Application for a Non-Material Amendment Following a Grant of Planning Permission

Non Material Amendment of previously approved 21/00707/VAR for Variation of condition 1 (Approved plans) of previously approved 20/00771/FUL for Demolition of existing agricultural buildings and development of 6 dwellings Dimmocks Cote 46 Stretham Road Wicken Cambridgeshire CB7 5XL.

To amend the design to the carport of plot 2.

17-491-4-196P - Rev A - Plot 2 - Car Port

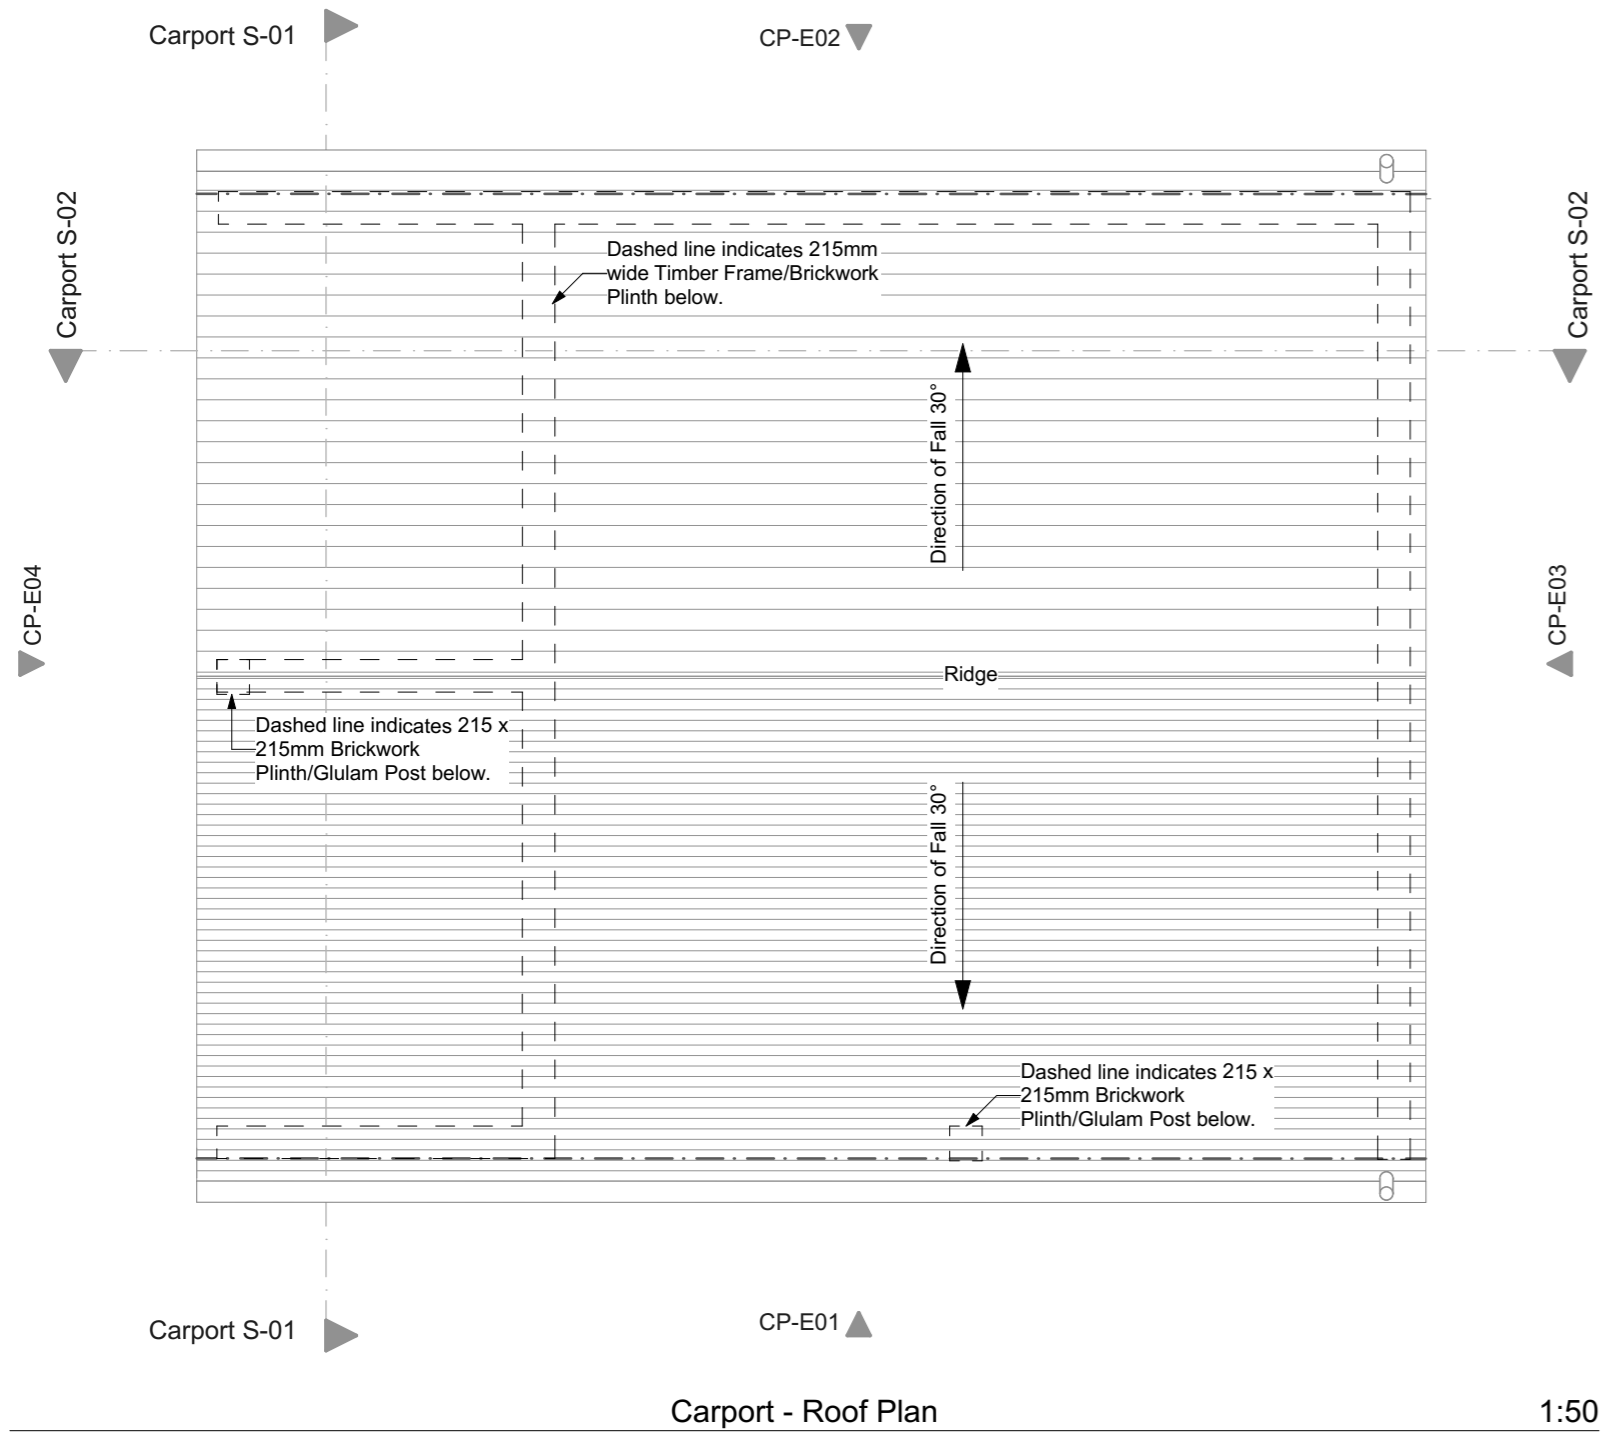
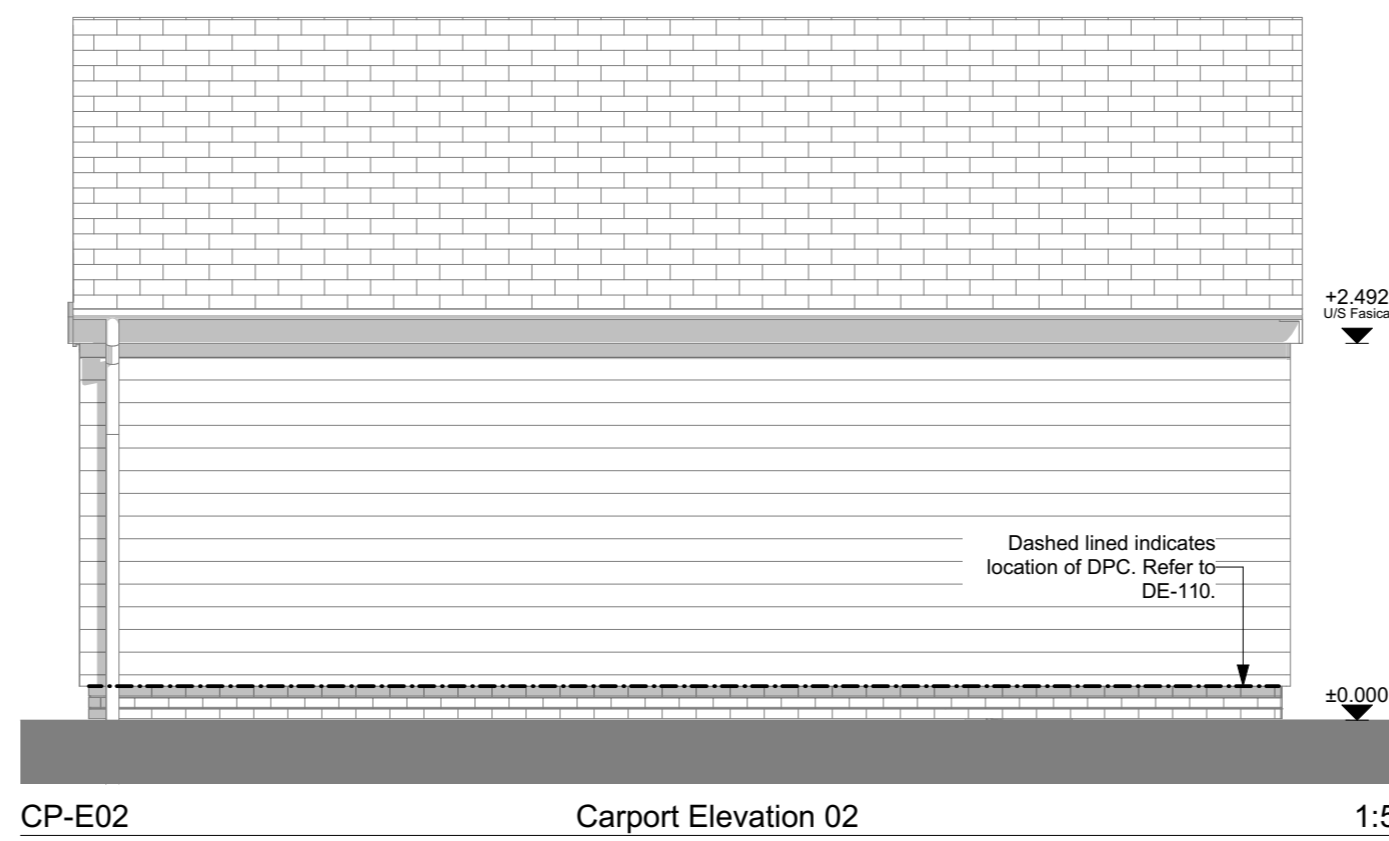
We are seeking to make changes to the Carport of Plot 2 only. We are removing the lean-to roof (where the log and bin store is located) and intend to continue the main pitched roof across here in its place. The sides of the bin and log store are to also be enclosed. Plots 3-6 will remain as original application.
